From: Elliott, Stanice [<mailto:staniceelliott@cabq.gov>]
Sent: Thursday, November 3, 2016 8:40 AM
To: Michael Balaskovits <mbalaskovits@bhinc.com>; Cordova, Camille C. <camillecordova@cabq.gov>
Subject: 1751 Bellamah Ave NW

Based upon the information provided in your submittal received 10-12-2016, the above referenced plan cannot be approved for PERM CO until the following comments are addressed:

STORM DRAIN
PLAN

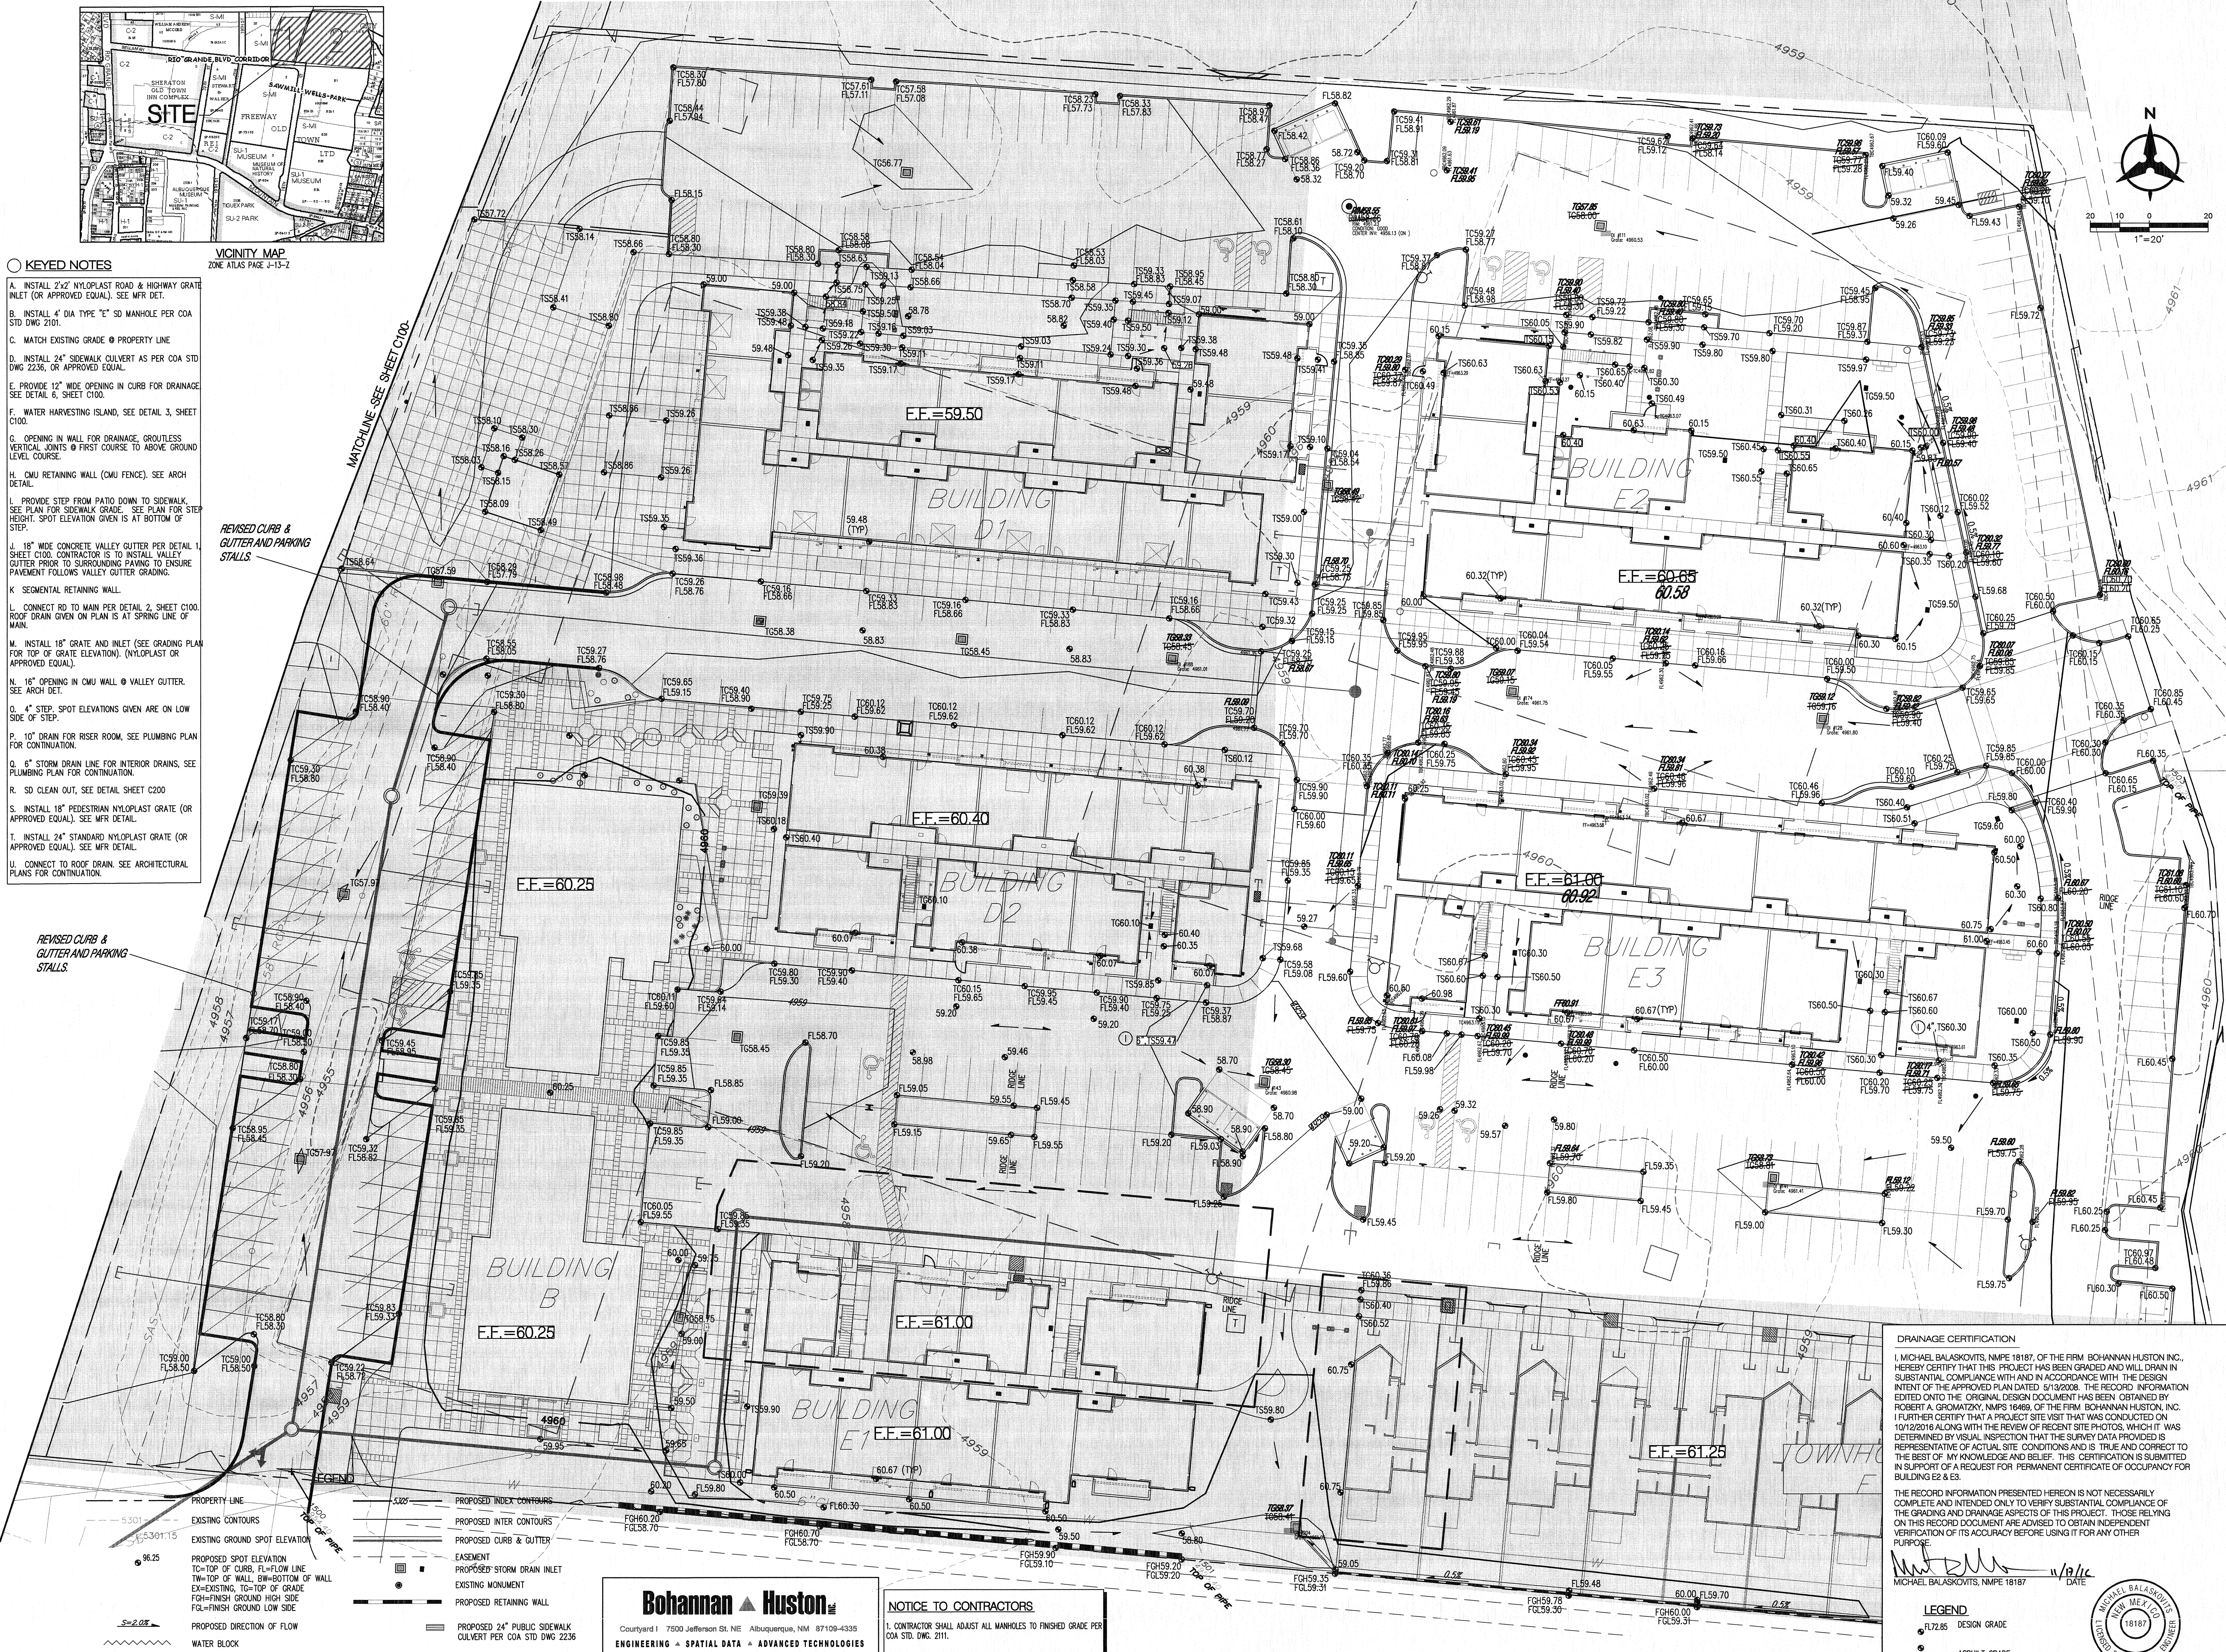
There are 3 area drains that need to be reconciled prior to release of CO PERM. We will release a 30-day extension for completion of these items.

- There are 3 area drains missing.
